Our Ref: A/117/17/HH

Town & Country Planning Act 1990 (as amended)
Town & country Planning (Development Management Procedure) (England) Order 2015
Application for Householder Planning Permission

Development Double garage
Location 49 Ashurst Way Angmering

Proposed floor plan

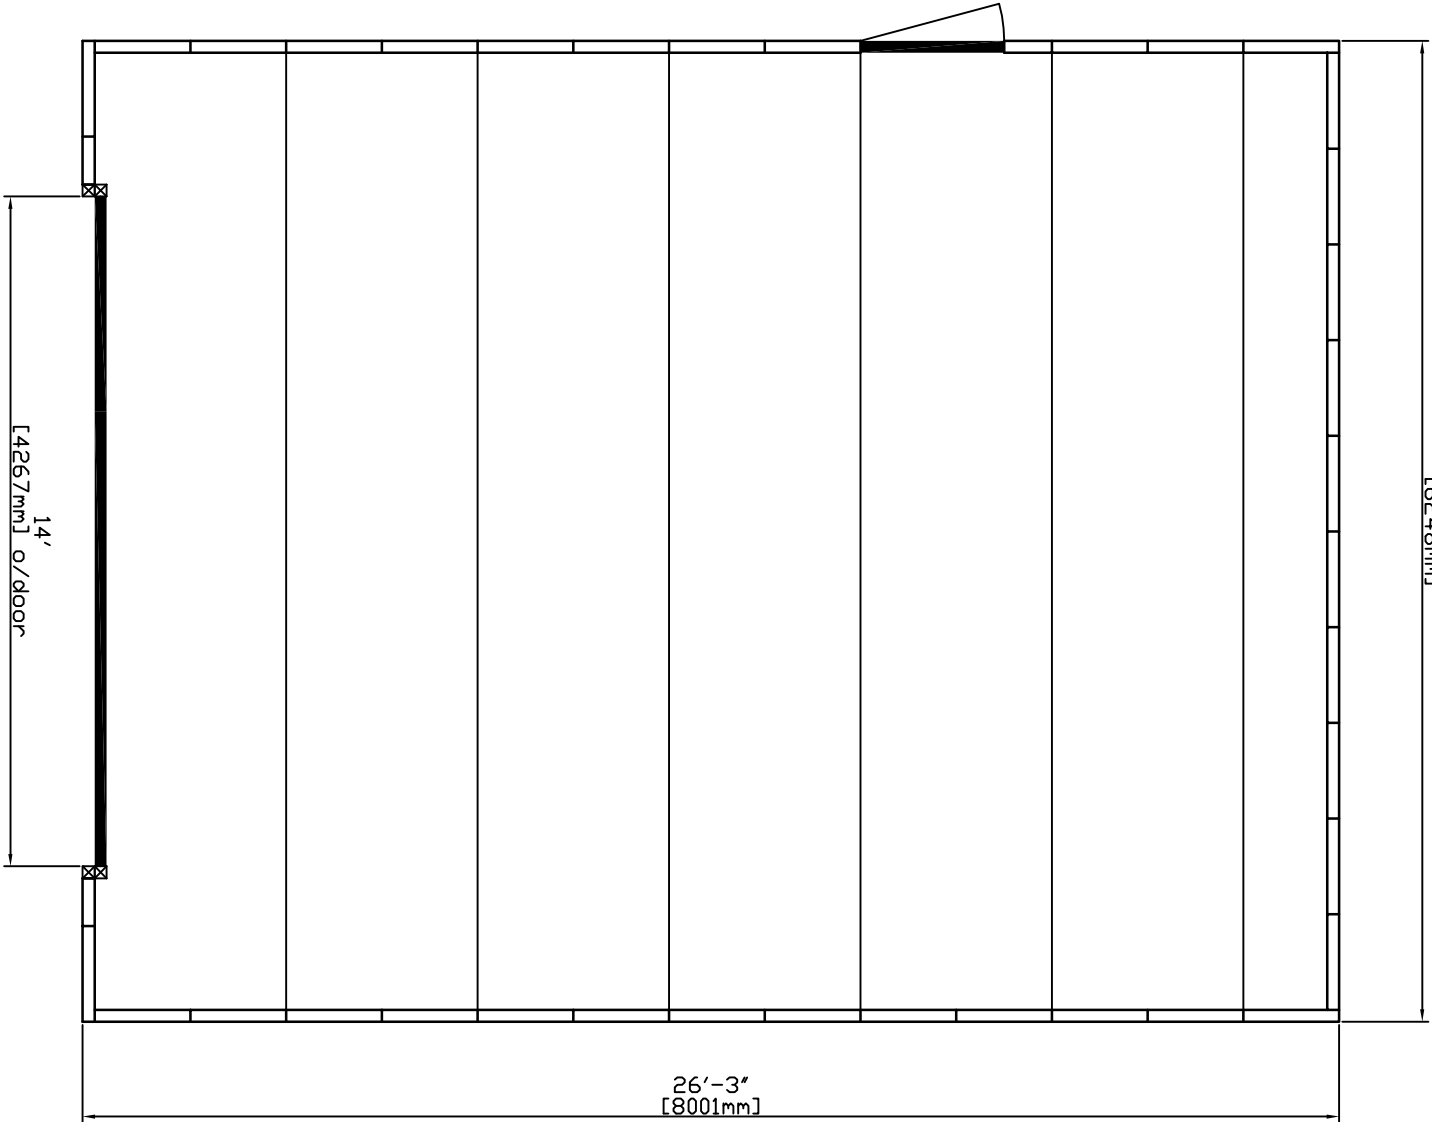
Floor Plans

Please submit 1 electronic or 3 paper copies of amended proposed floor plans at a scale of 1:50 or 1:100 titled 'Proposed floor plans'
